**Town and Country Planning Act 1990
Application for Non-Material Amendments to Reserved Matters Approval
19/00441/REM with regards to**

**Dorchester Phase 5R, Heyford Park, Upper Heyford, Bicester, Oxfordshire, OX25
5HD**

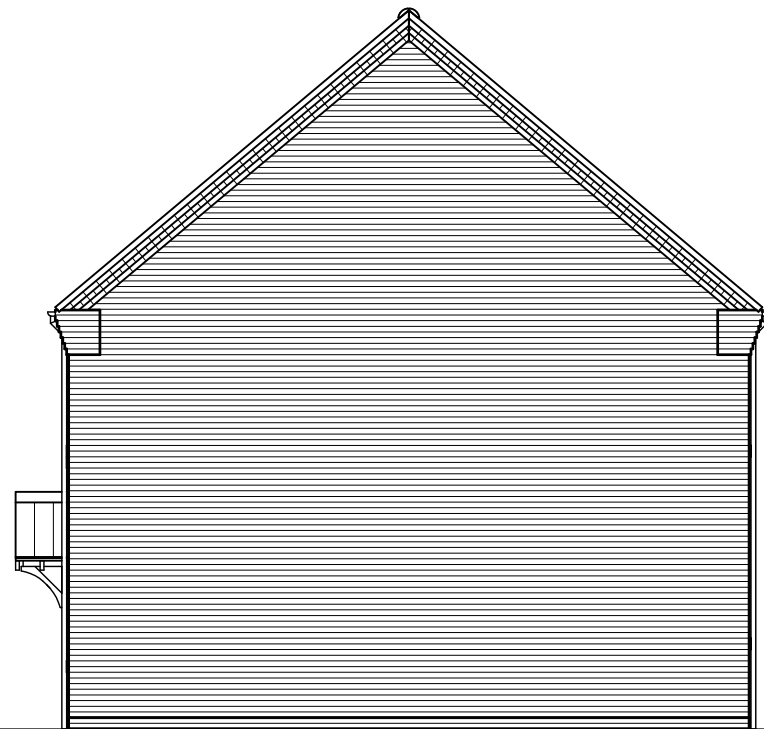
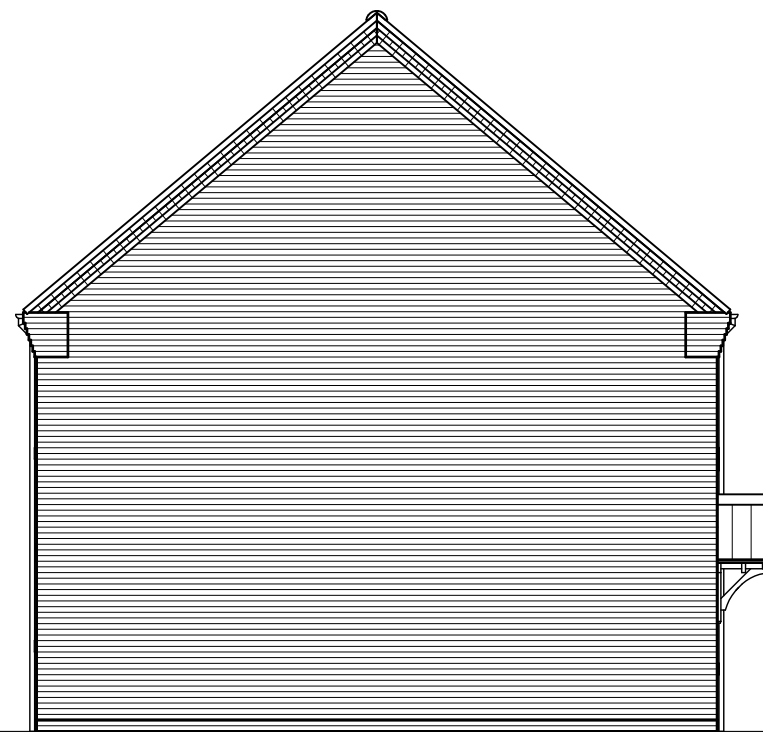
- Amended cill and header materials to match walling brick;
- Adjustment and refinements to rear boundary and landscaping treatments;
